July 26, 2022

Re: **Groundhog PRD – PA22-019 – Concurrency Recommendation**

Groundhog Land Development Company, LLC, is proposing construction of a 25-lot single-family Planned Residential Development (PRD) on 4.635 acres, located at 5110 83<sup>rd</sup> Ave NE and further identified by APN: 00590700010500. The existing residence located on site is to be demolished with the proposed development.

**GRADING AND COMPOSITE UTILITY PLAN**  
GROUNDHOG PLANNED RESIDENTIAL DEVELOPMENT

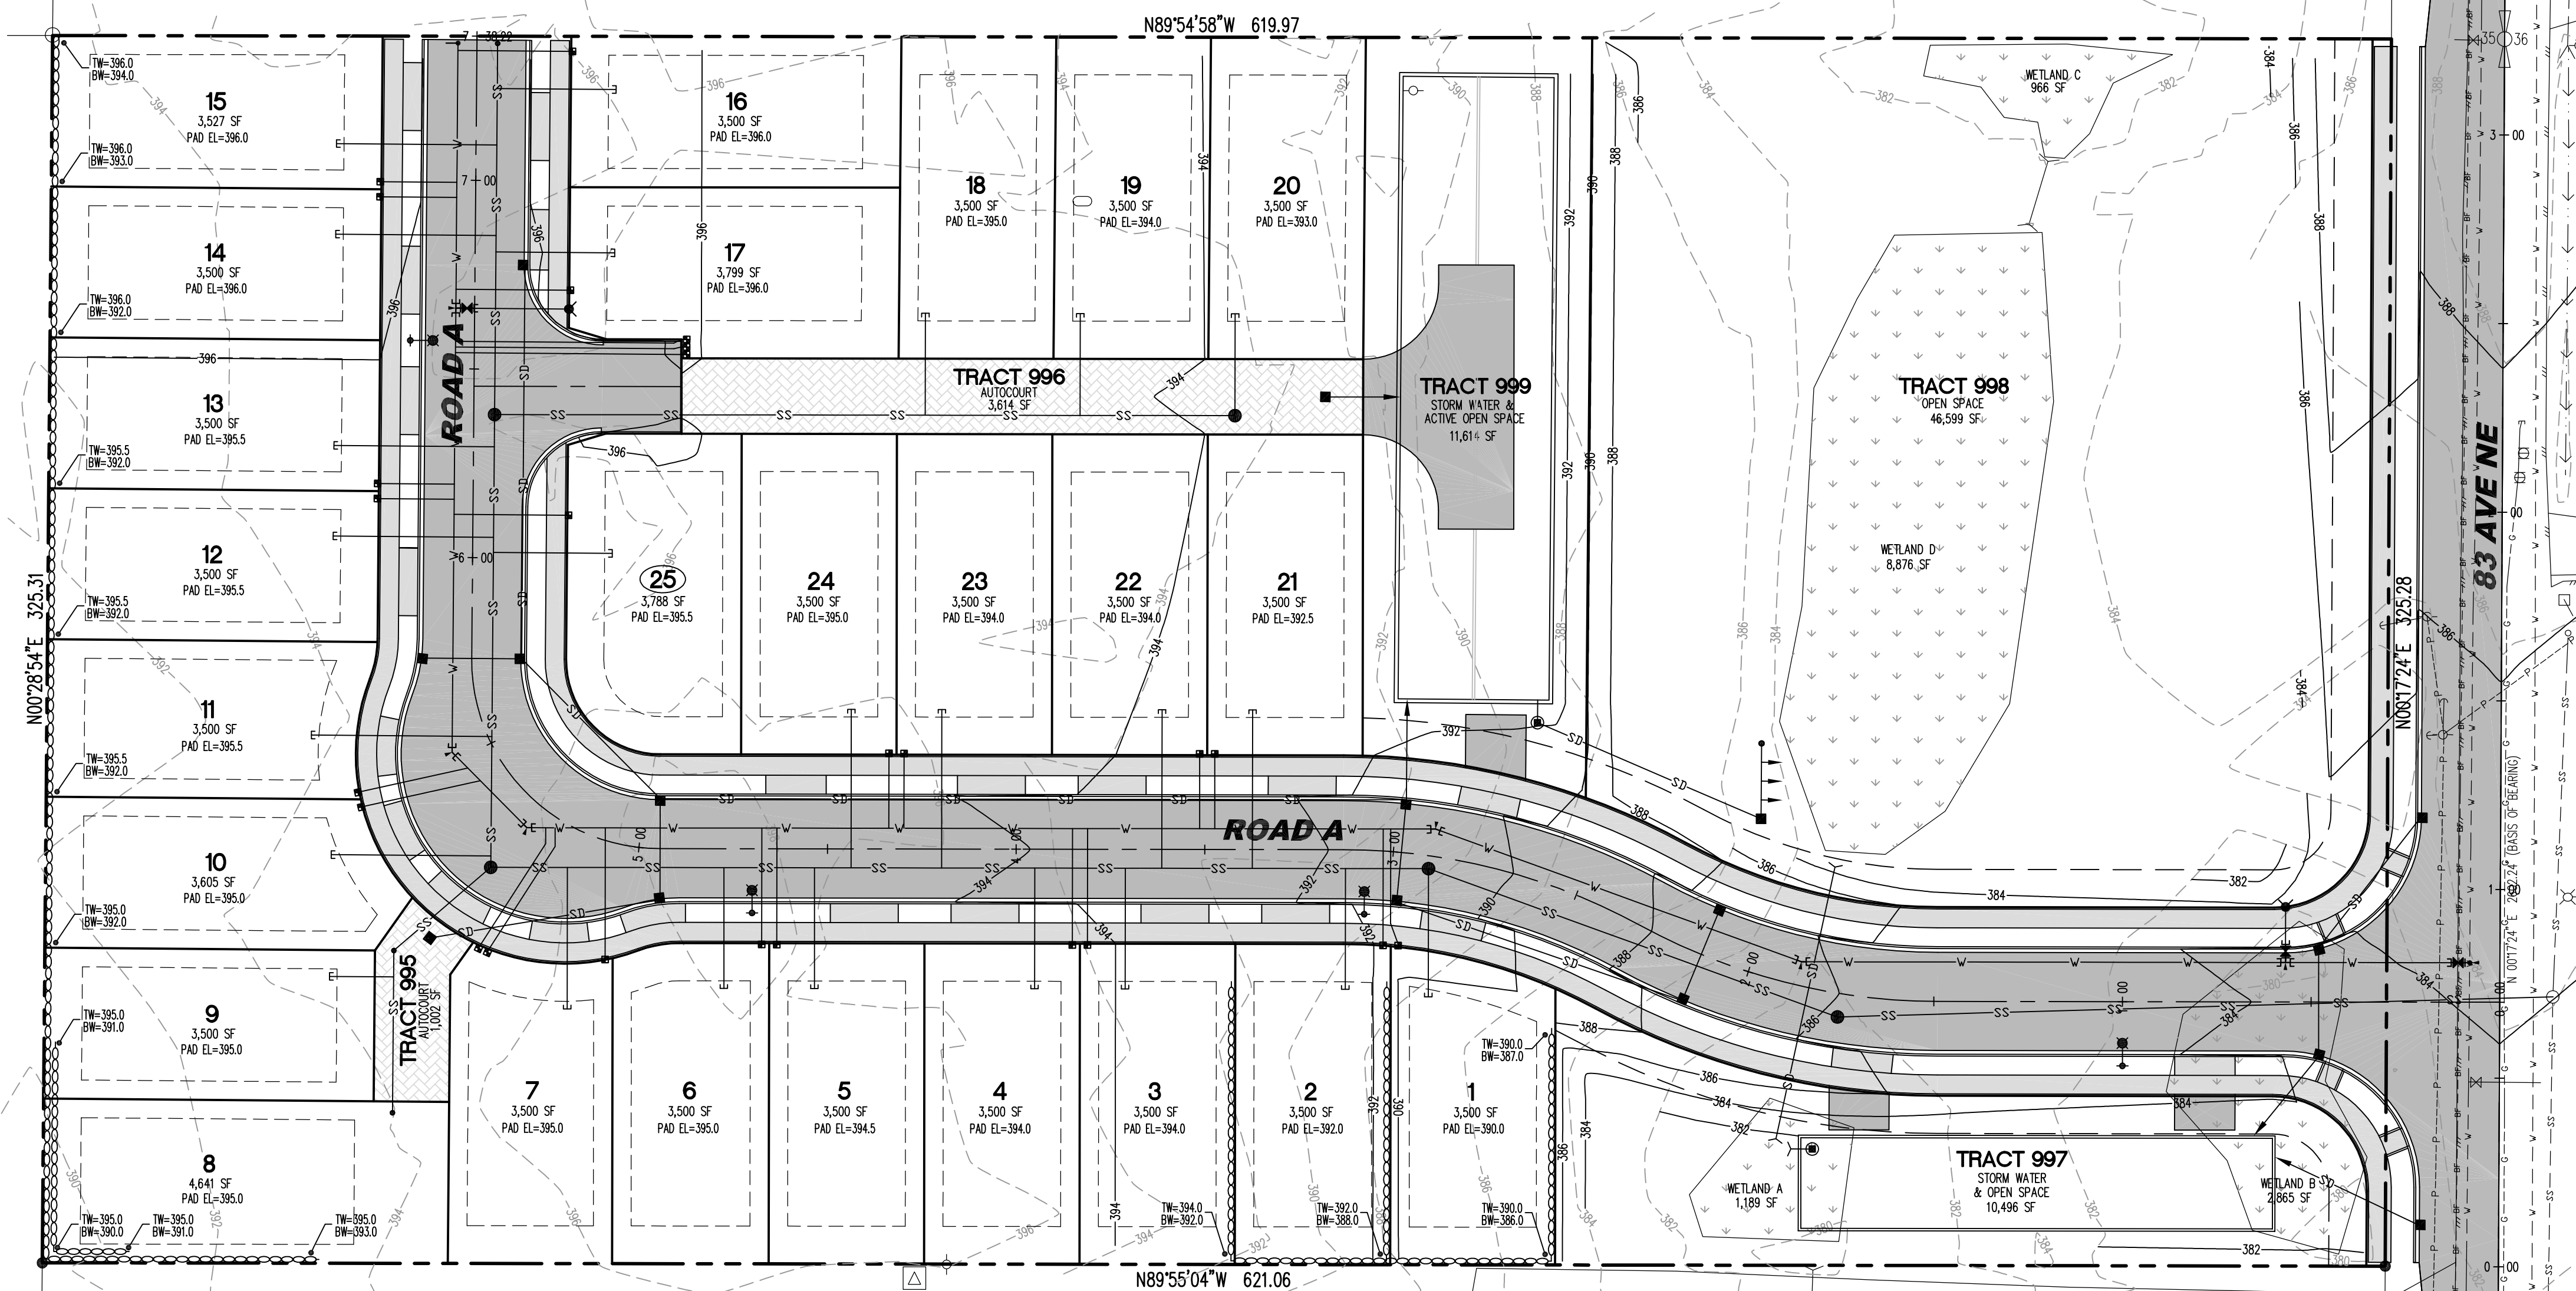
3. The joint use autocourts (Tract 995 and 996, or as amended) shall be constructed with scored concrete, paving blocks, bricks, or other ornamental pavers to clearly indicate that the entire surface is intended for pedestrians as well as vehicles, as outlined in the City of Marysville Design Guidelines and Engineering Design and Development Standard (EDDS) Section 3-219. A detail of the surfacing of the autocourt will be required to be provided on the civil construction plans and approved by the City Engineer.

**TYPICAL ROAD SECTIONS**  
 GROUNDHOG PLANNED RESIDENTIAL DEVELOPMENT  
 5110 83 AVENUE NE, MARYSVILLE, WA  
 PORTION OF NE 1/4 SE 1/4 OF SEC 35, TWP 30N, RGE 5E, W.M.  
 DATE: APRIL 2022  
 SCALE: H: AS SHOWN V: AS SHOWN

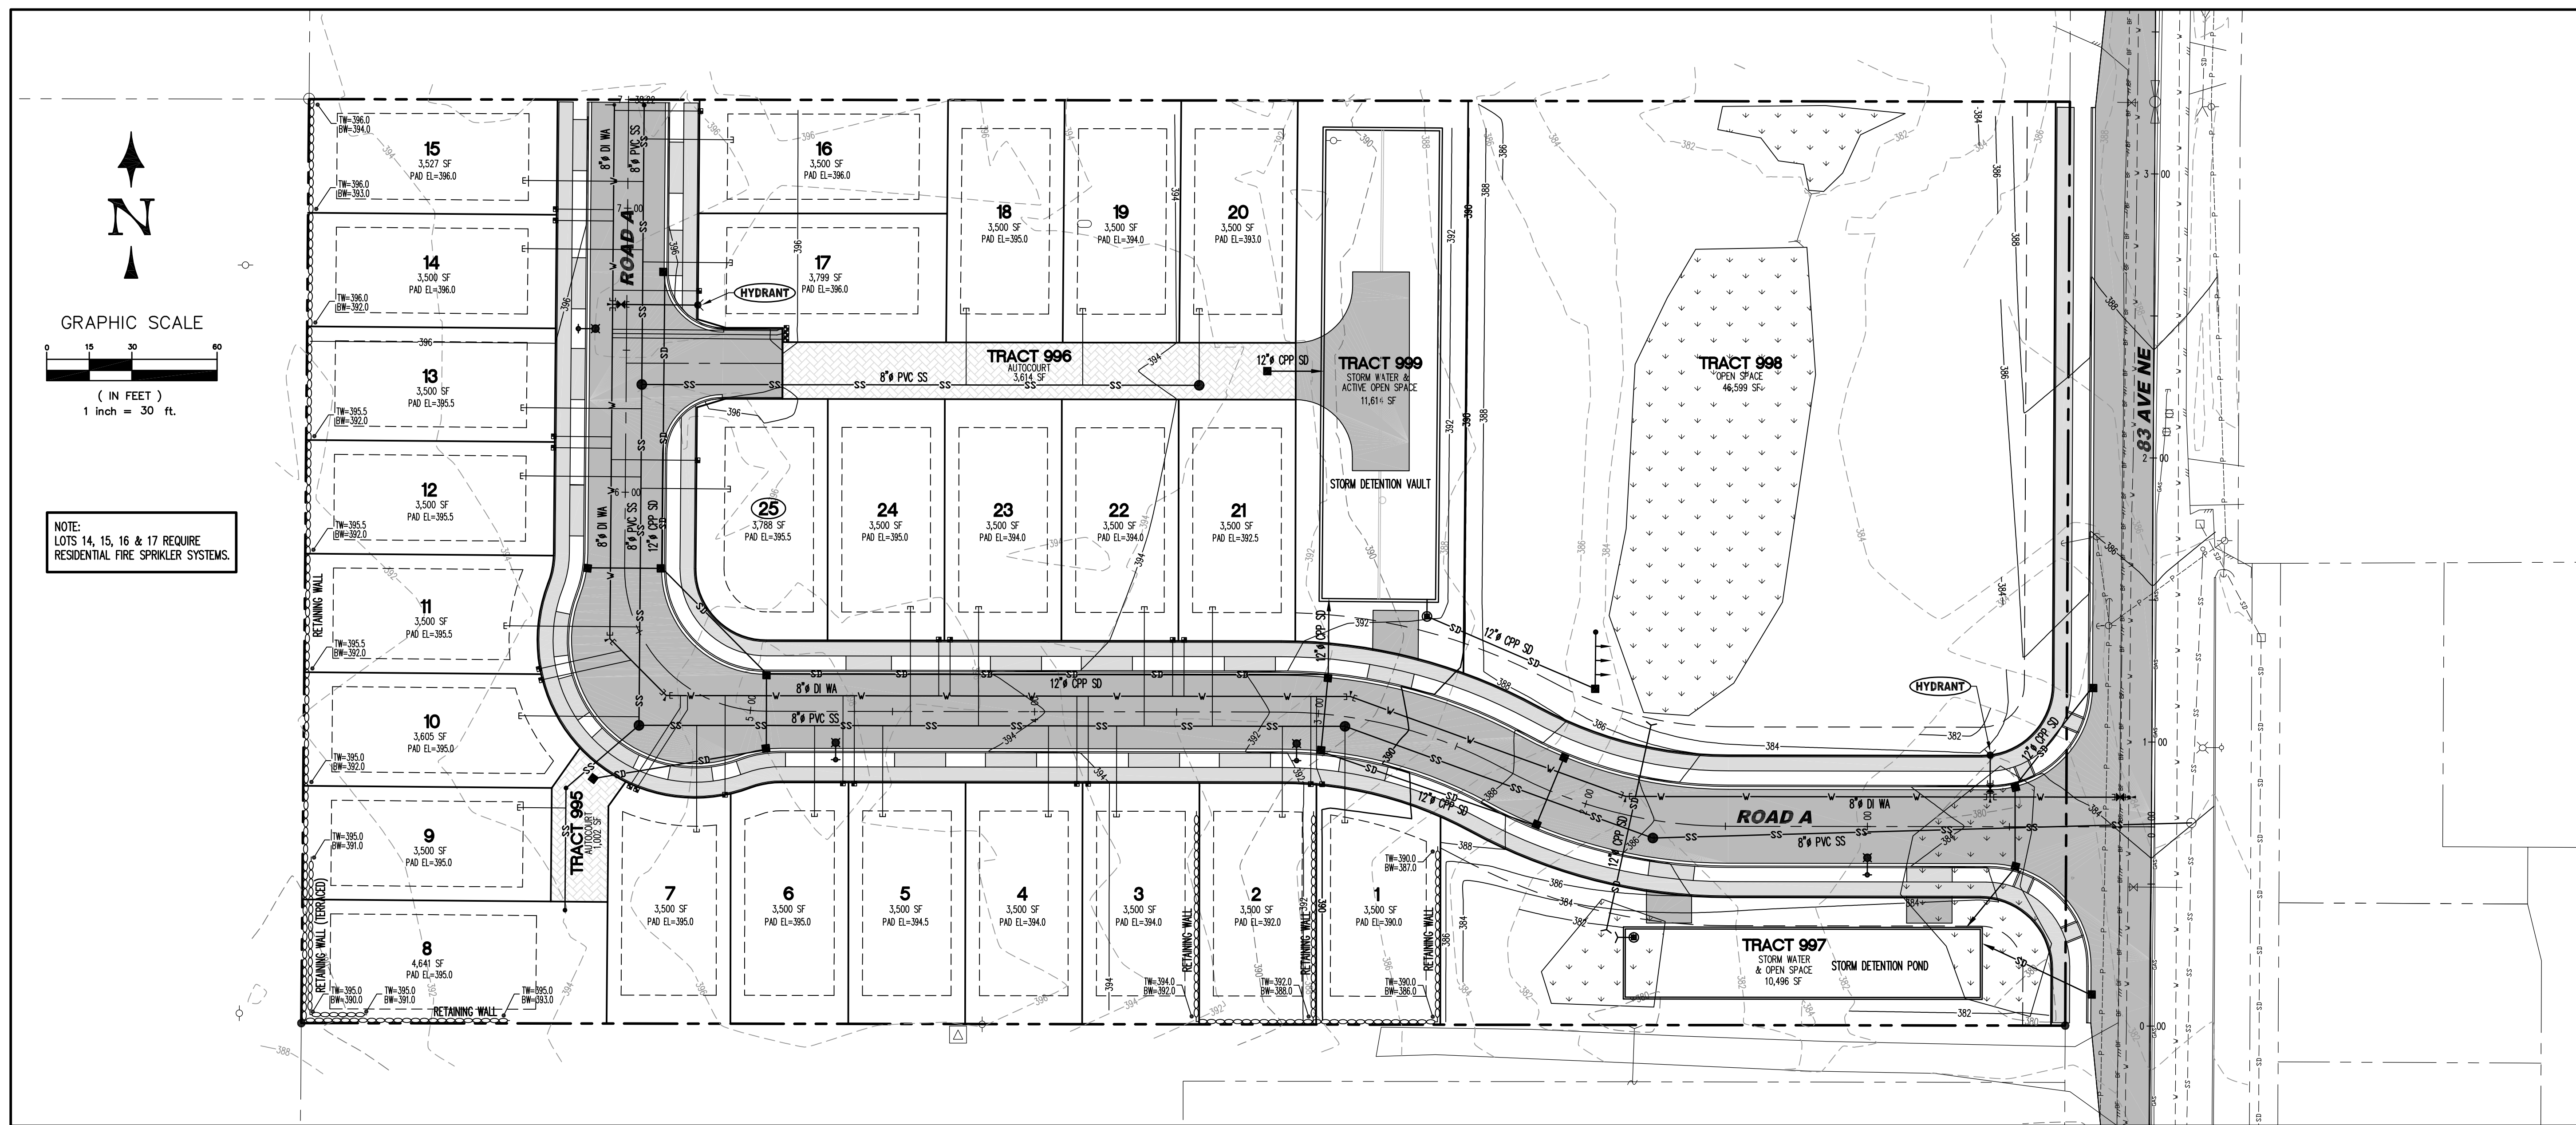
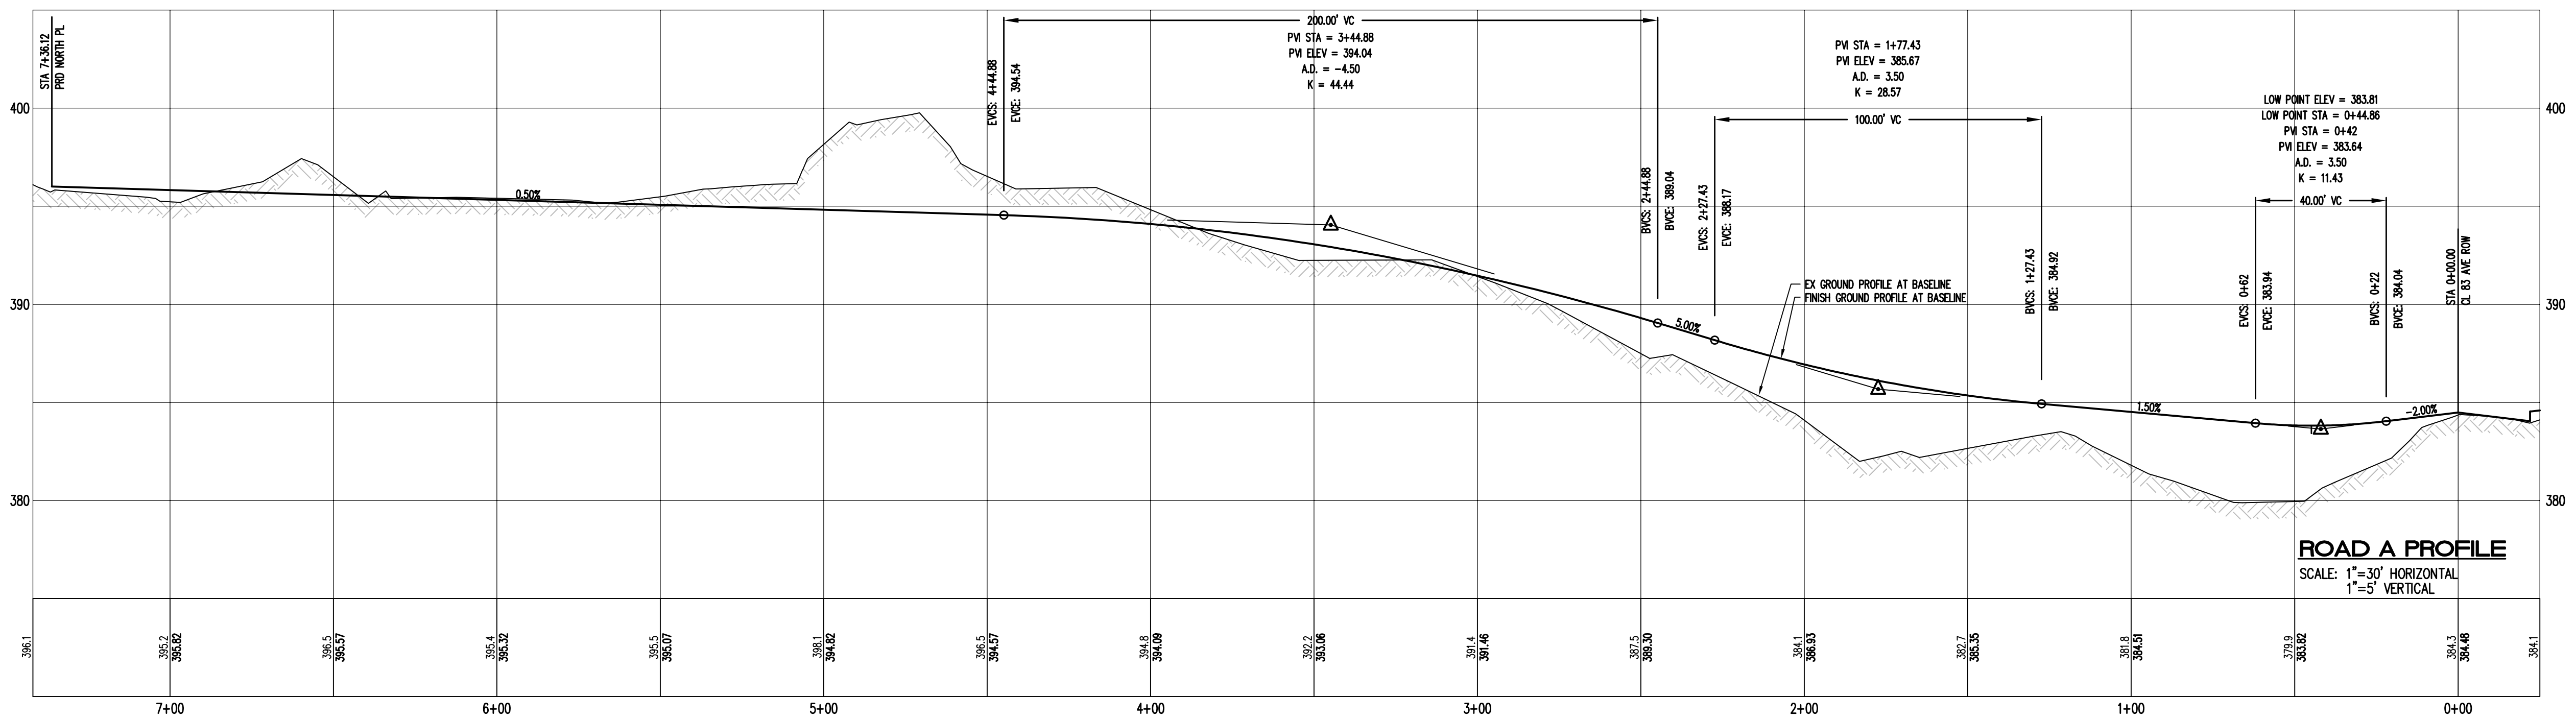
1. The applicant shall be required to construct frontage improvements along 83<sup>rd</sup> Avenue NE and the internal plat road (Road A), prior to final plat approval. Roadway improvements, channelization, site access and lighting plans shall be required to be reviewed and approved by the City Engineer, prior to construction plan approval.

2. The applicant shall be required to dedicate public right-of-way in order to accommodate the required frontage improvements along 83<sup>rd</sup> Avenue NE and the internal plat road (Road A) in accordance with MMC 12.02A.110(1)(c), *Dedication of Road right-of-way – Required setbacks*. Right-of-way widths and required dedication shall be determined by the City Engineer.
